**From:** Nolan, Chris <Chris.Nolan@lancashire.gov.uk>  
**Sent:** 14 December 2017 13:56  
**To:** Rachel Horton; planning  
**Subject:** RE: D3.2017.1066 - Unit A Whalley Industrial Park Clitheroe Road Whalley Rv

Planning Application No: 3/2017/1066  
Grid Ref: 373635 437604  
Proposal: Proposed COU from existing B1 (light industrial) to D2 (Gym).  
Location: Unit A Whalley Industrial Park Clitheroe Road Whalley BB7 9WP

SITE BLOCK PLAN

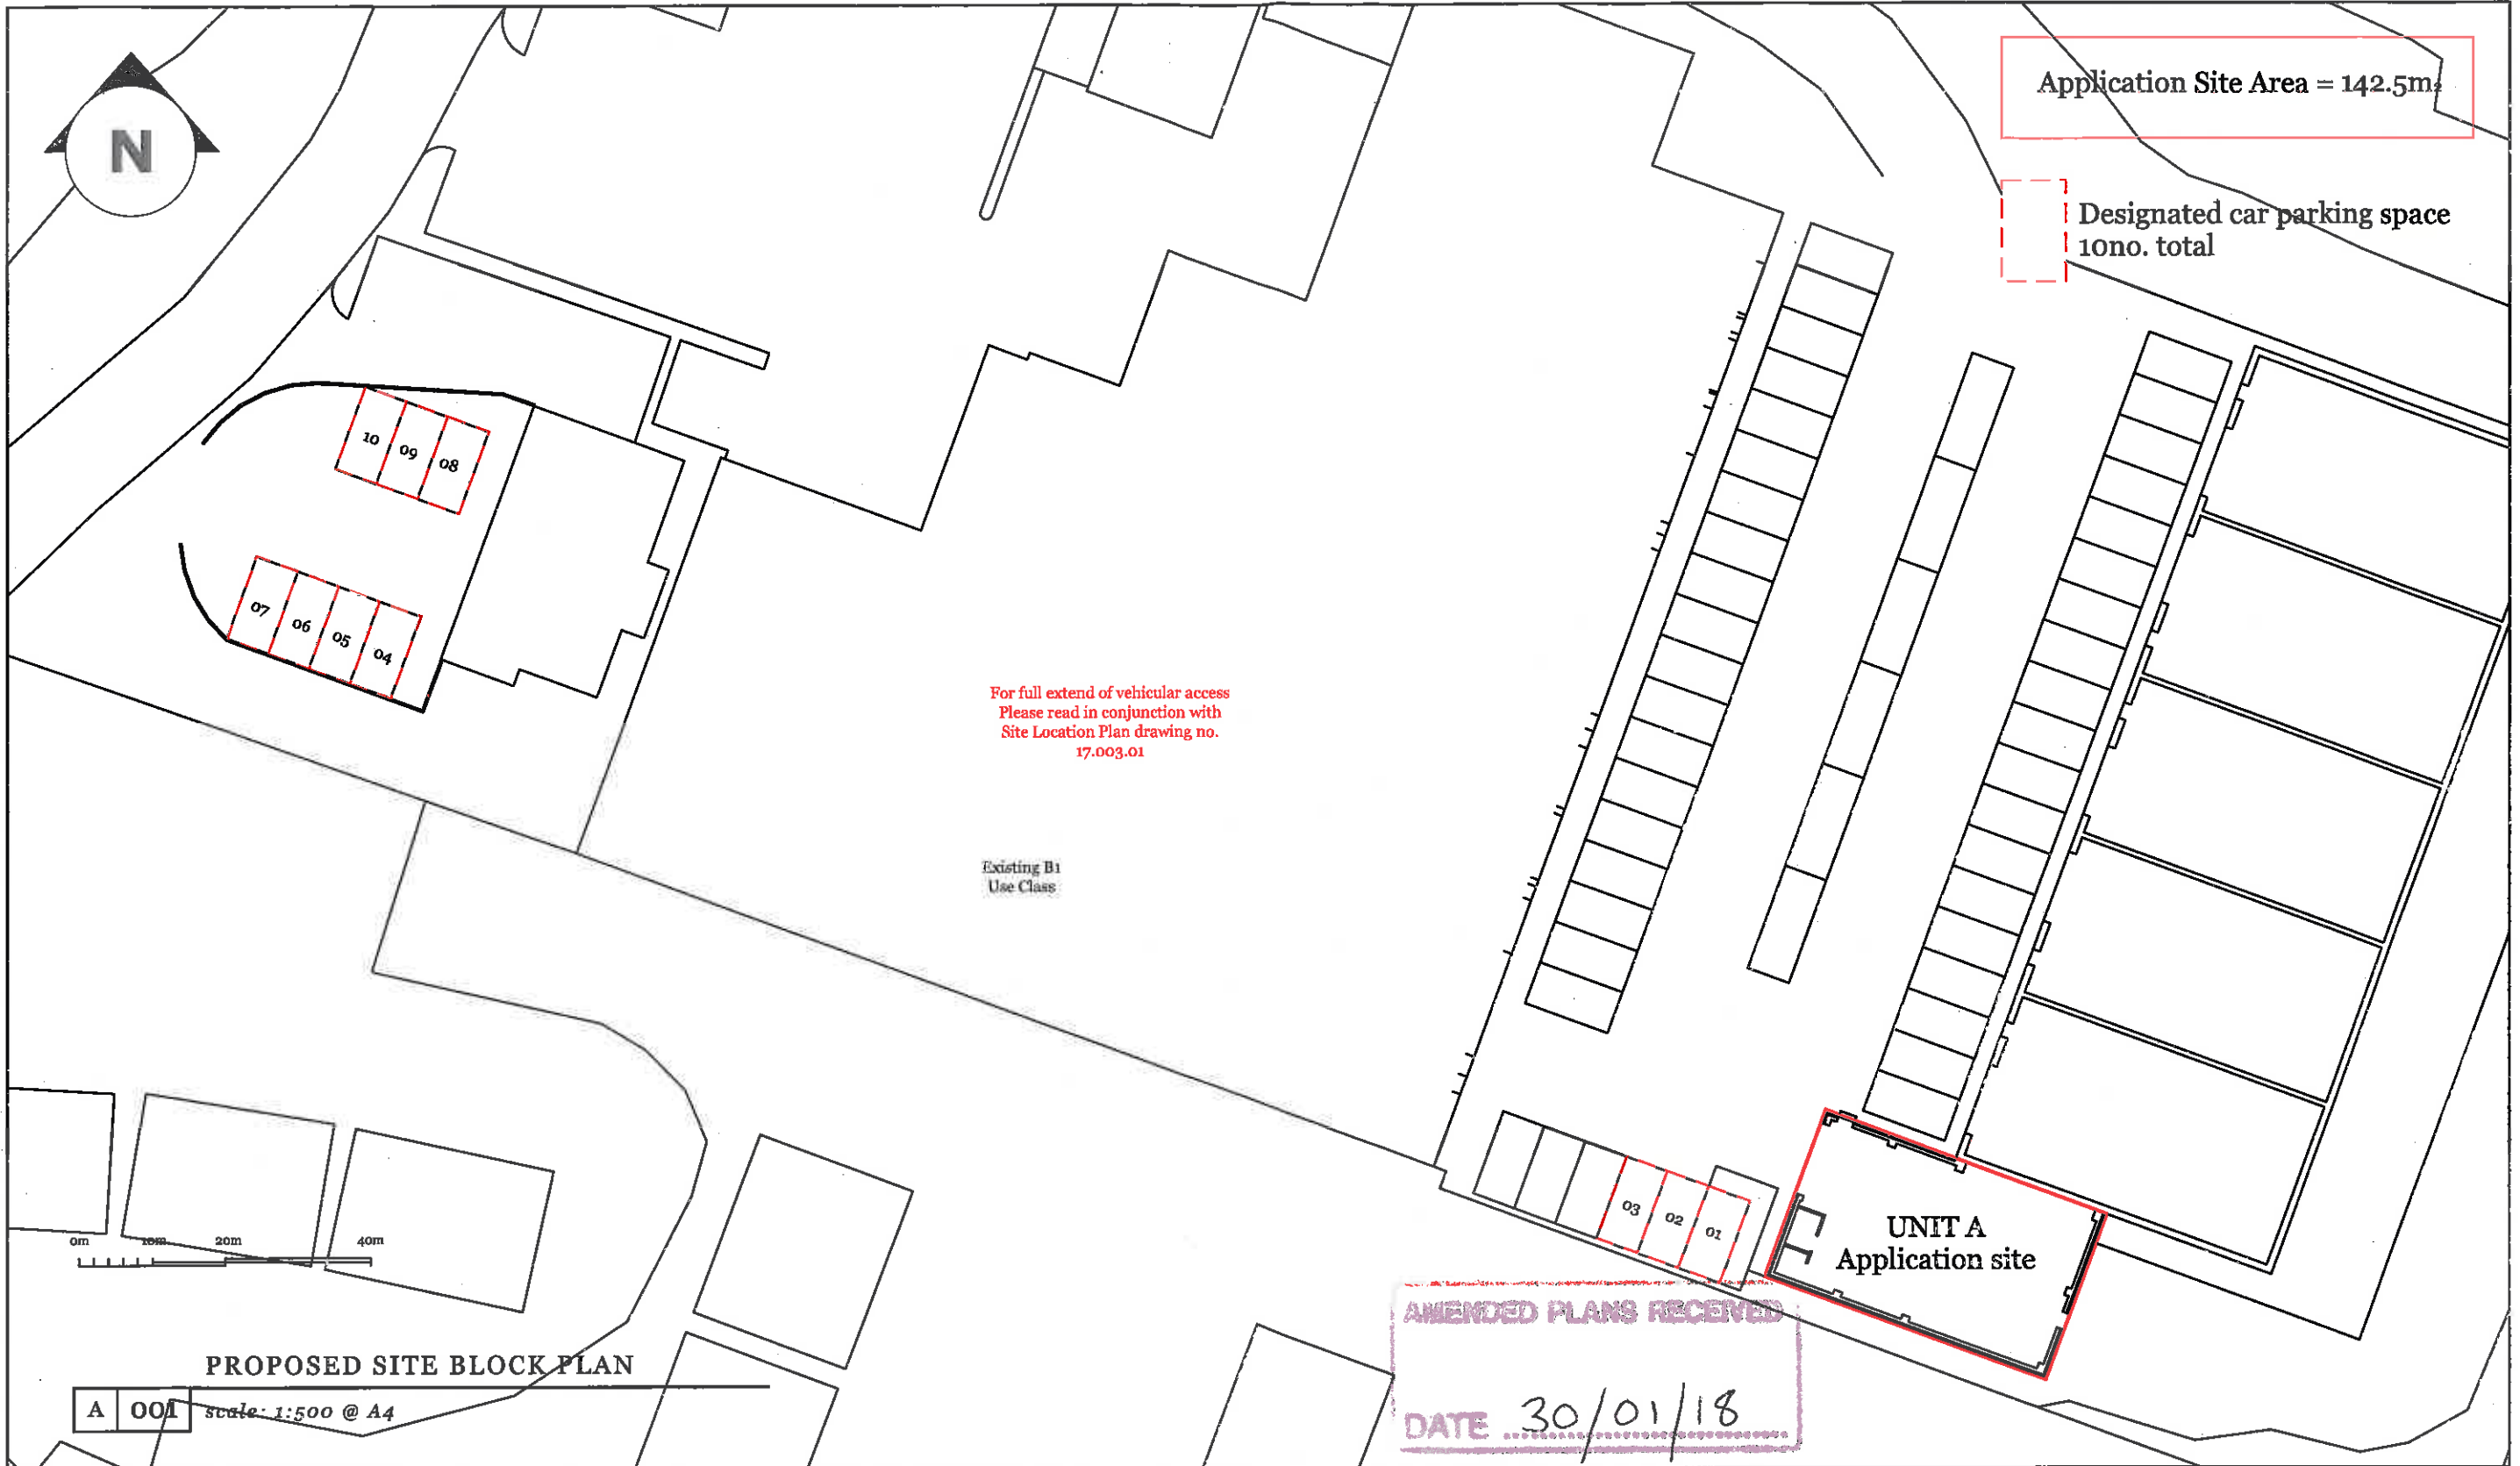
With regard to the above planning application and the submitted parking plan. As much as this would seem to be acceptable I would still be asking for the parking bays to be correctly marked out and a signed as reserved for the gym. I could see that this would not be a problem with most of the bays but bays 7&8 as marked on the plan may be difficult.

Once this has been achieved I would not raise objections on highway grounds.
